## Online Comment

**Application** H16-0110-17  
**Location** 1 Woolram Wygate Spalding PE11 1NX  
**Proposal** Change of use from office accommodation to house of multiple occupation (HMO)

**Name** PSH  
**Address** Private Sector Housing Community and Neighbourhood Services

FLOOR PLAN - PROPOSED
LOCATION PLAN

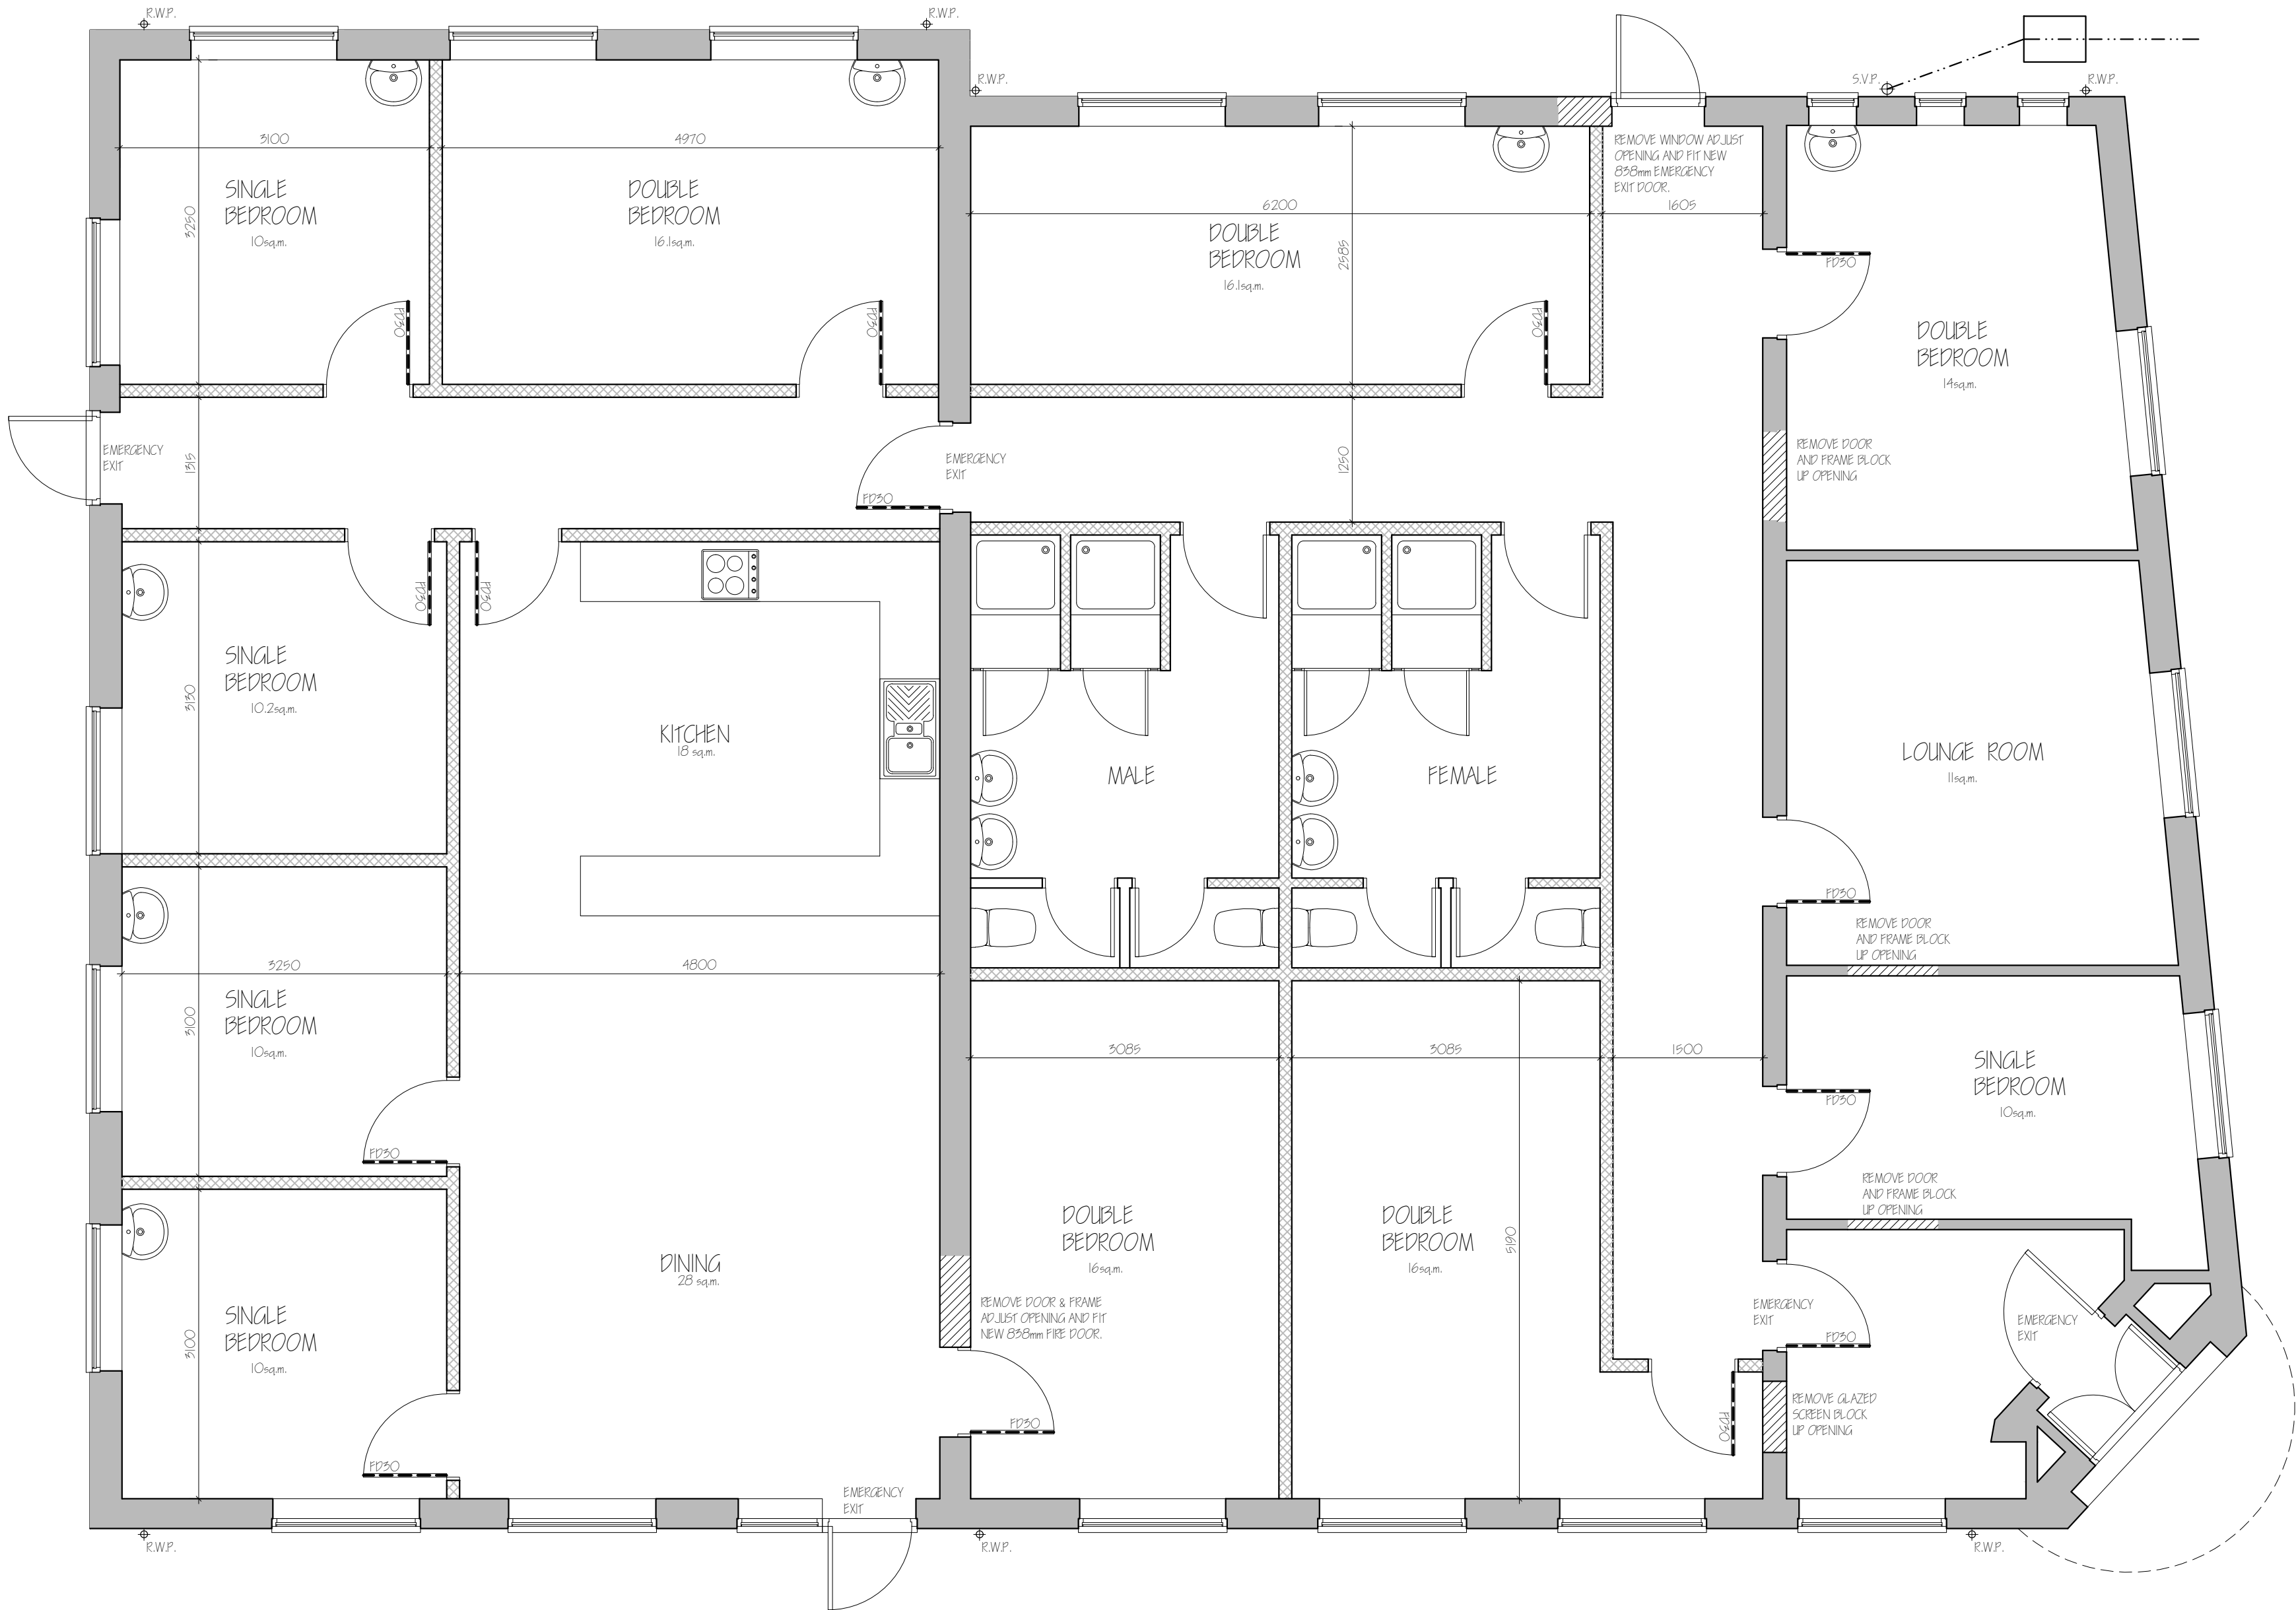
To comply with HMO regulations 1 set of facilities is required per 5 persons. The kitchen is only showing 1 cooker and 1 sink. This is inadequate for the proposed numbers.
